cd review1.pdf Markup Summary

SF-23-001
22_00x

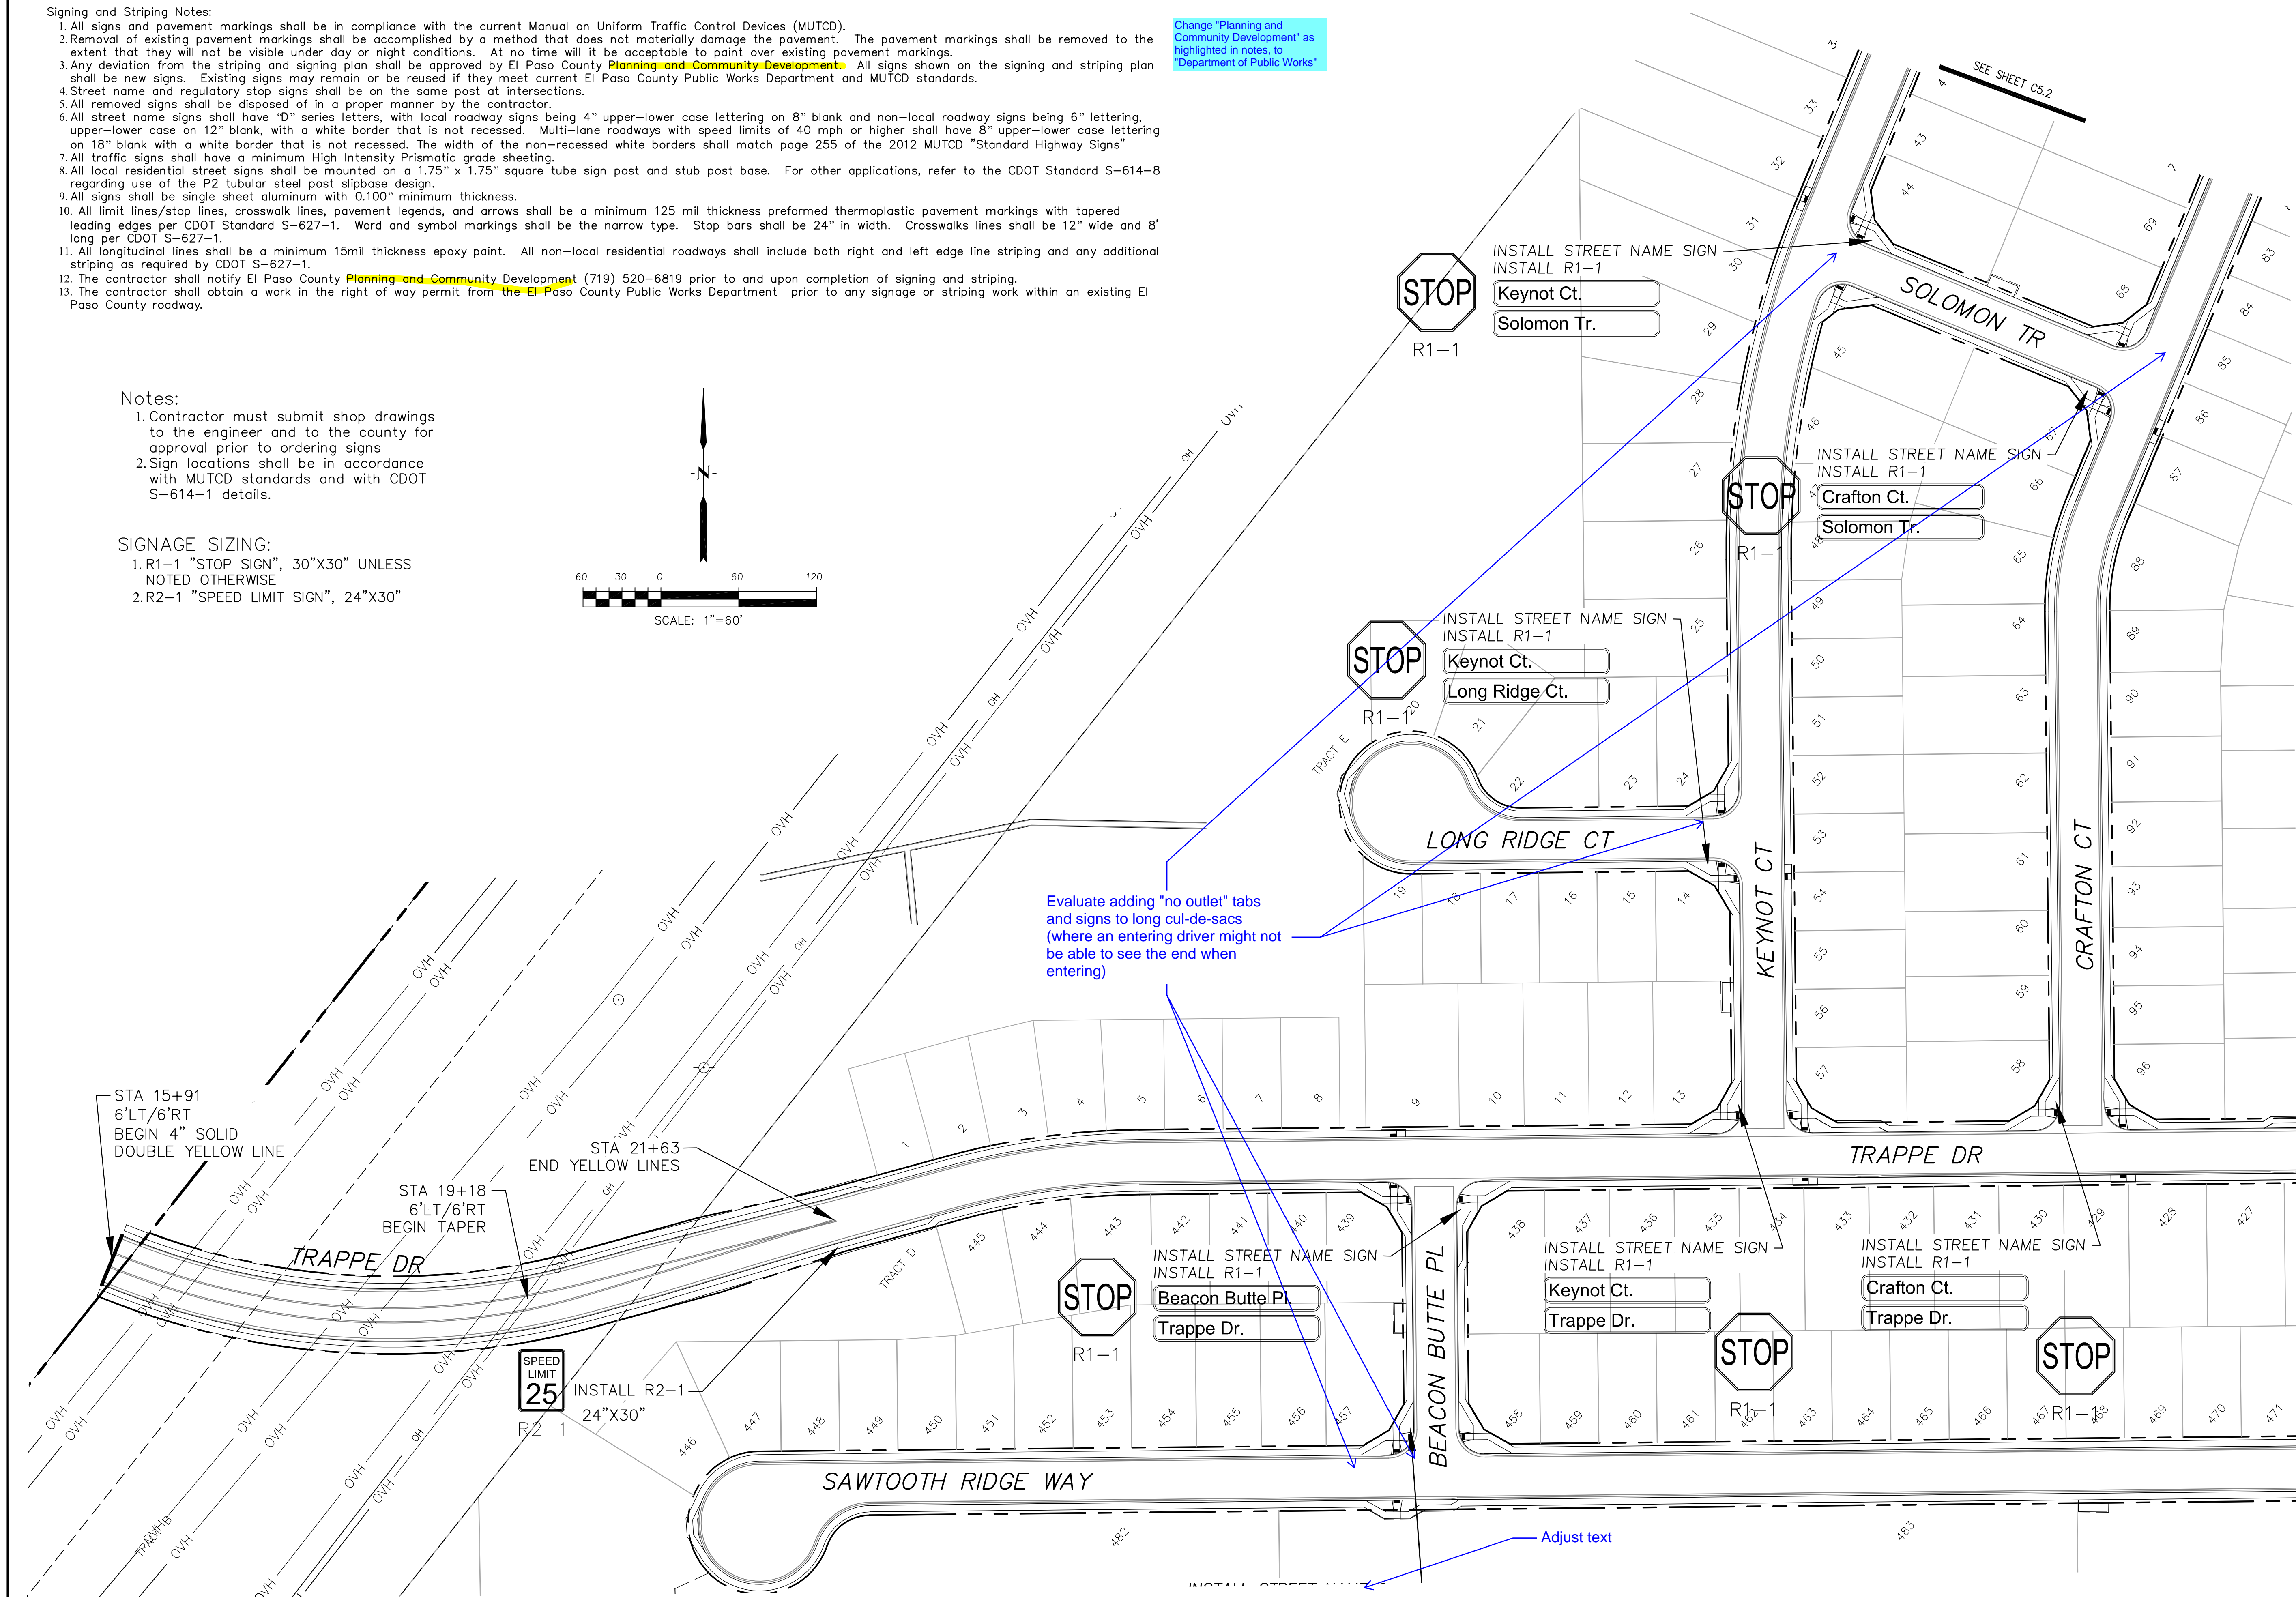
Change "Planning and
Community Development" as
highlighted in notes, to
"Department of Public Works"

Change "Planning and Community Development"
as highlighted in notes, to "Department of Public
Works"

note changed

SAWTOOTH RIDGE WAY

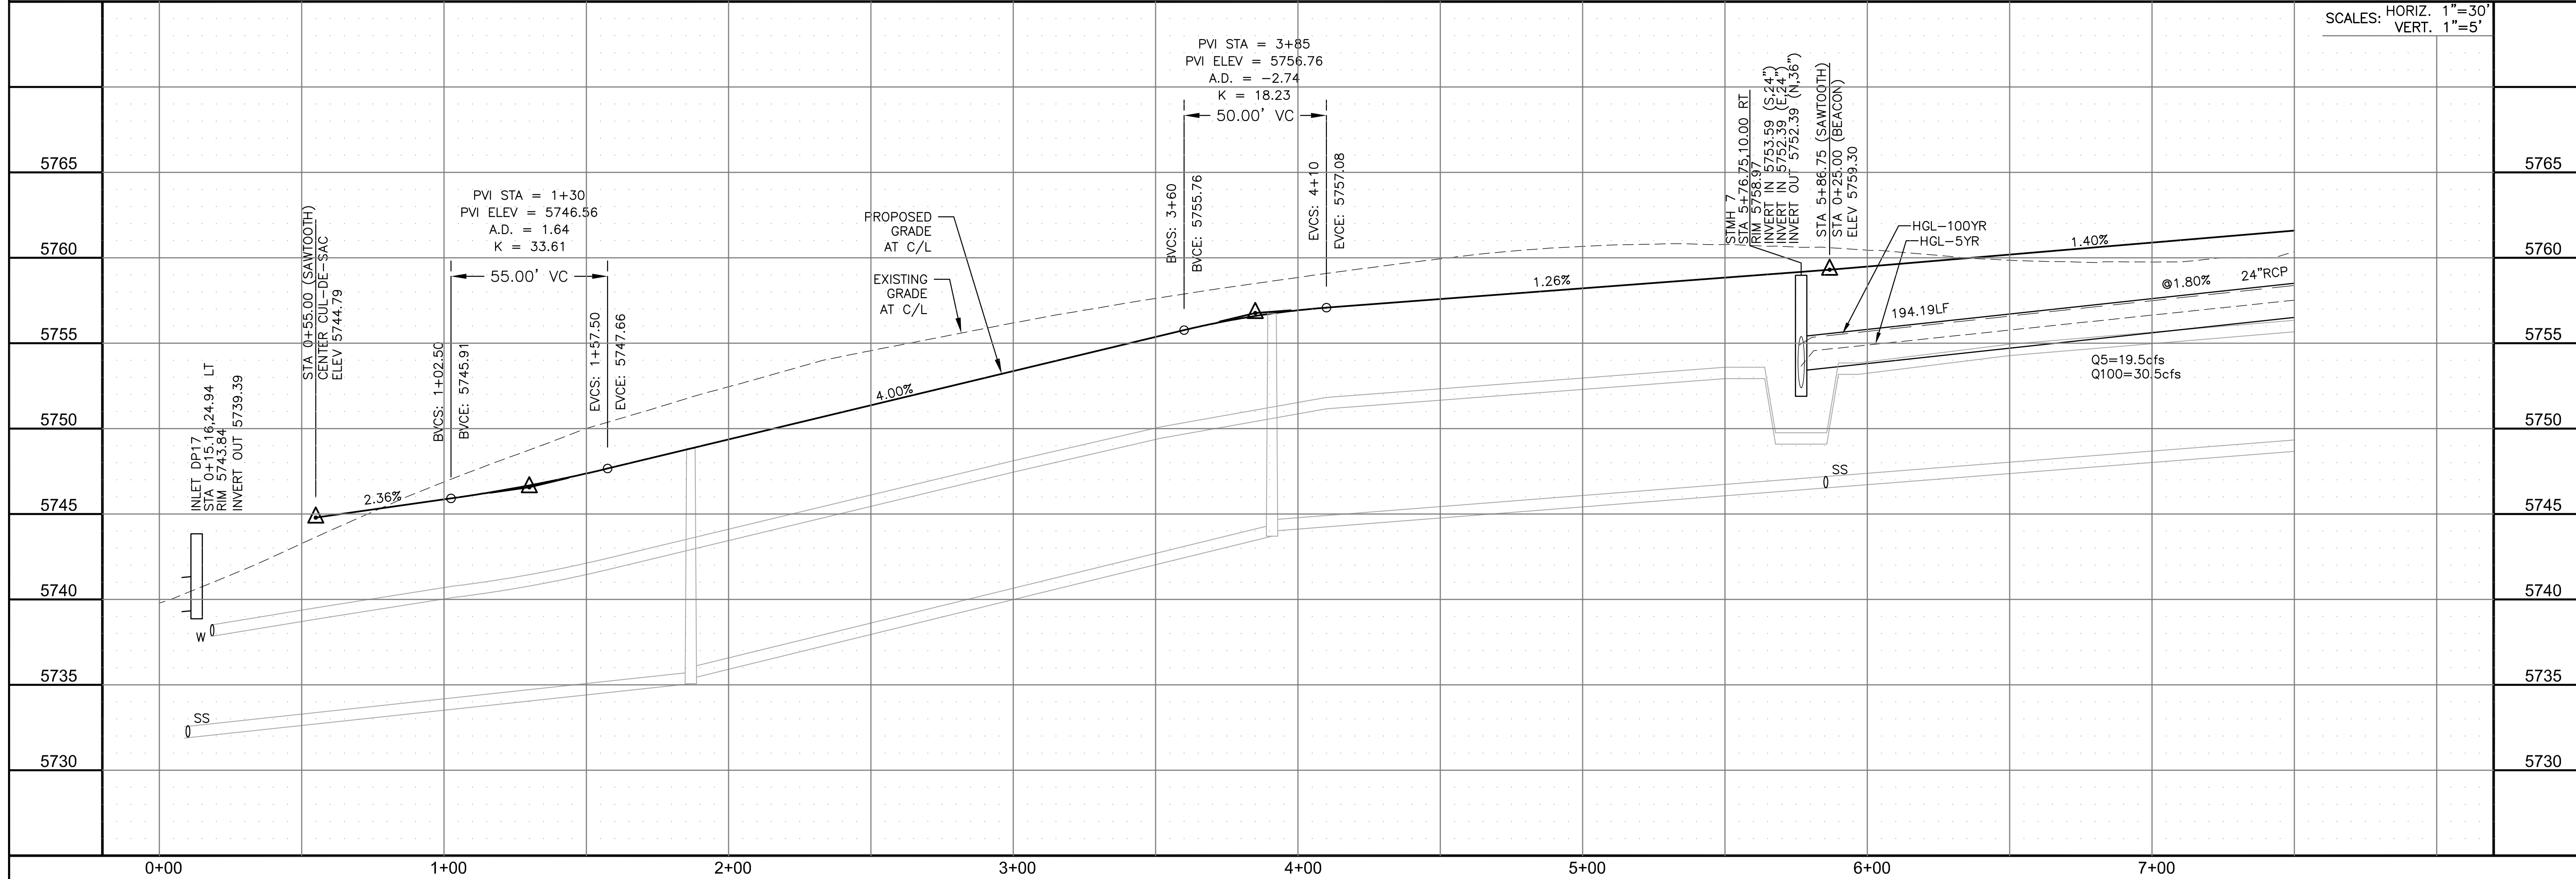
Please provide profile for cul-de-sac bubble

profile added
